Our Ref: GPDA002/2019

Pre-Development Application Advice 56 Beane Street, Gosford (Lot 30 in DP1250970)

I refer to your pre-development application (Pre-DA) meeting held on Friday 1 November 2019 in relation to a proposed residential flat building (for affordable housing) at the above site. I provide this written advice for your records.

01 Communal Open Space Diagram
1:200

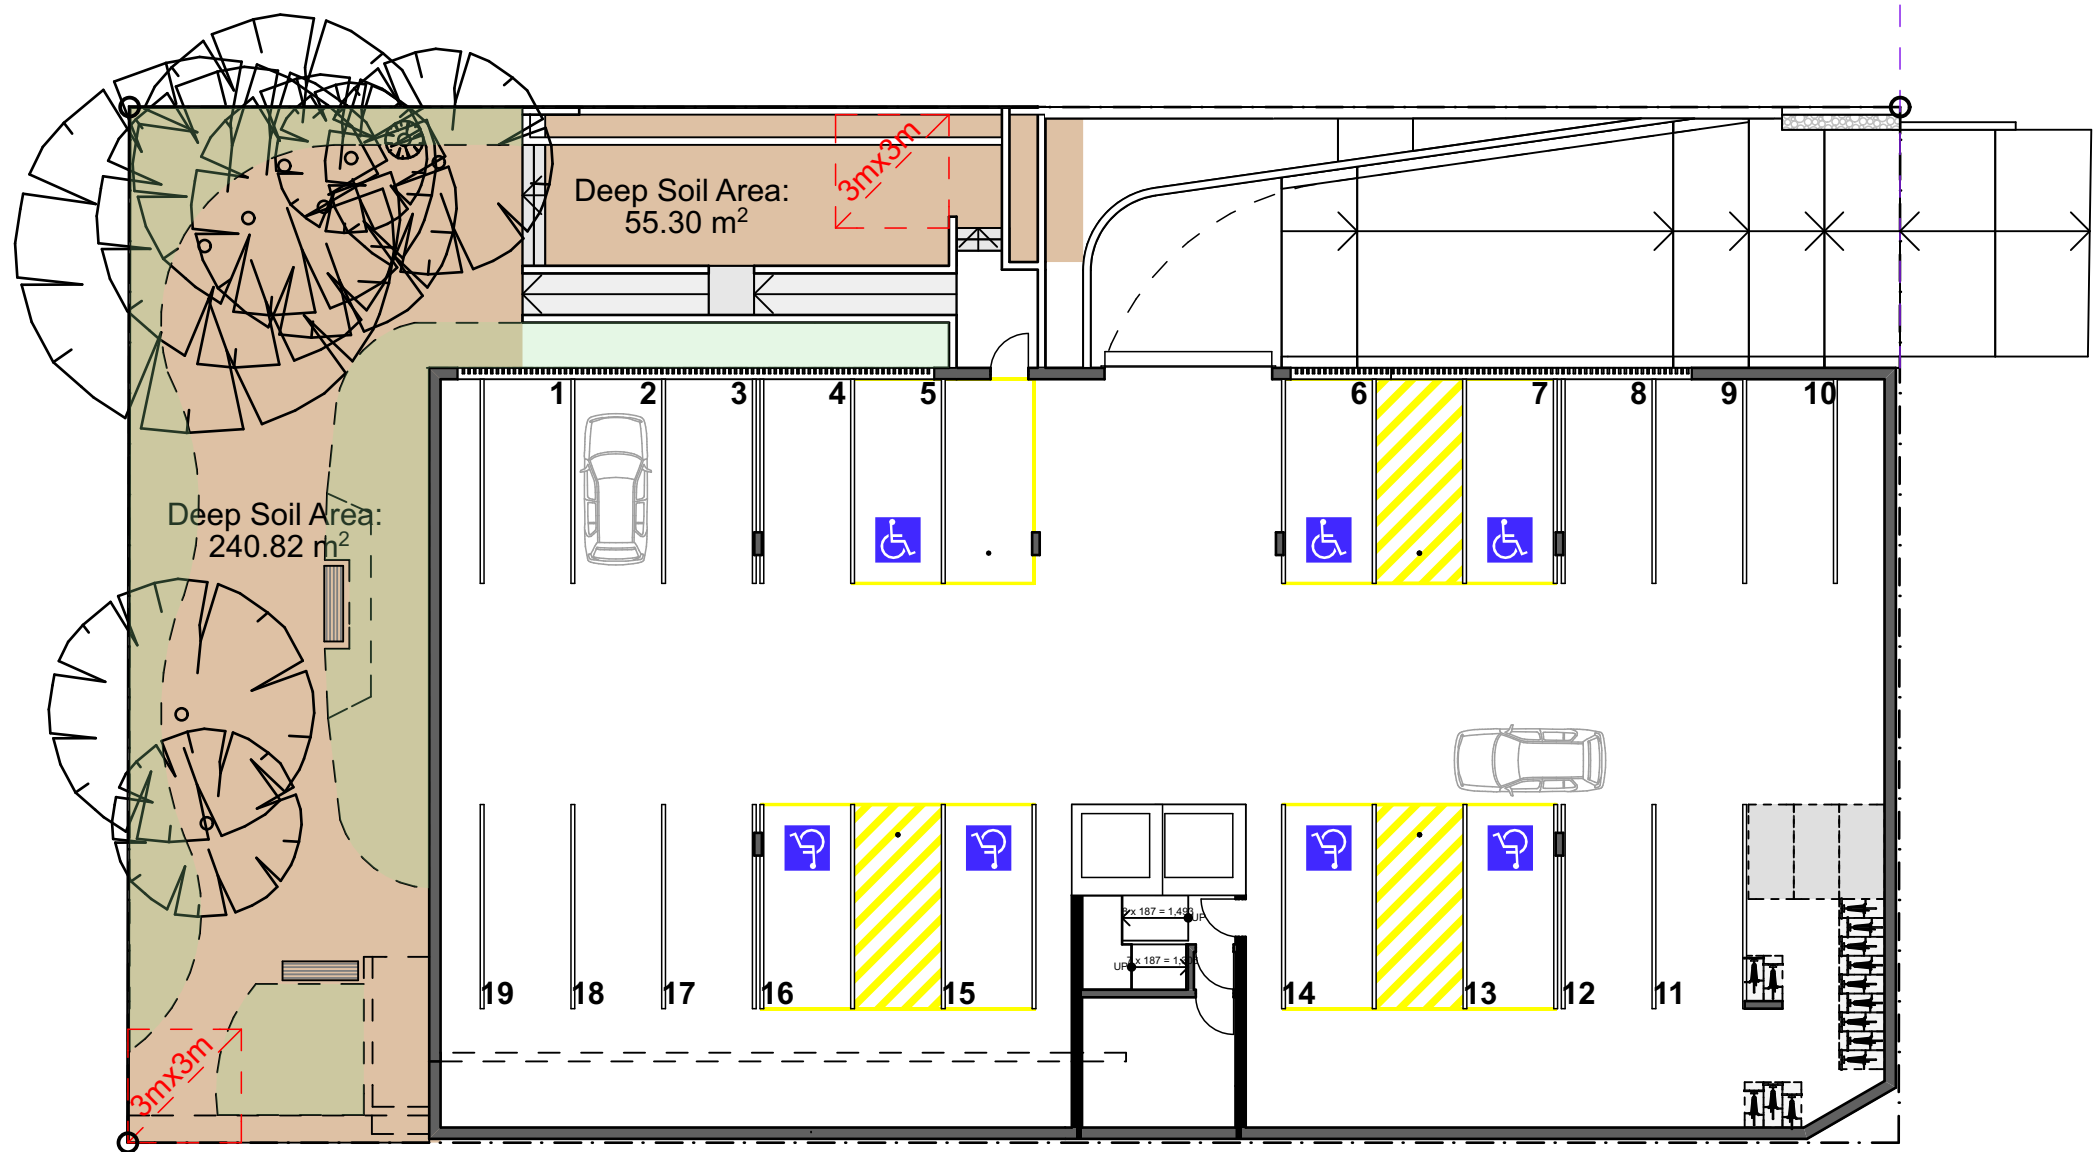
- Consider architectural issues identified in Central Coast Council's advice dated 25 September 2019.
- The proposed communal open space area appears to offer limited amenity and is located away from building access points, near the carpark and it's ventilation grilles. Investigate options to improve the proposed Communal Open Space area, including the resident access arrangements and environmental amenity.
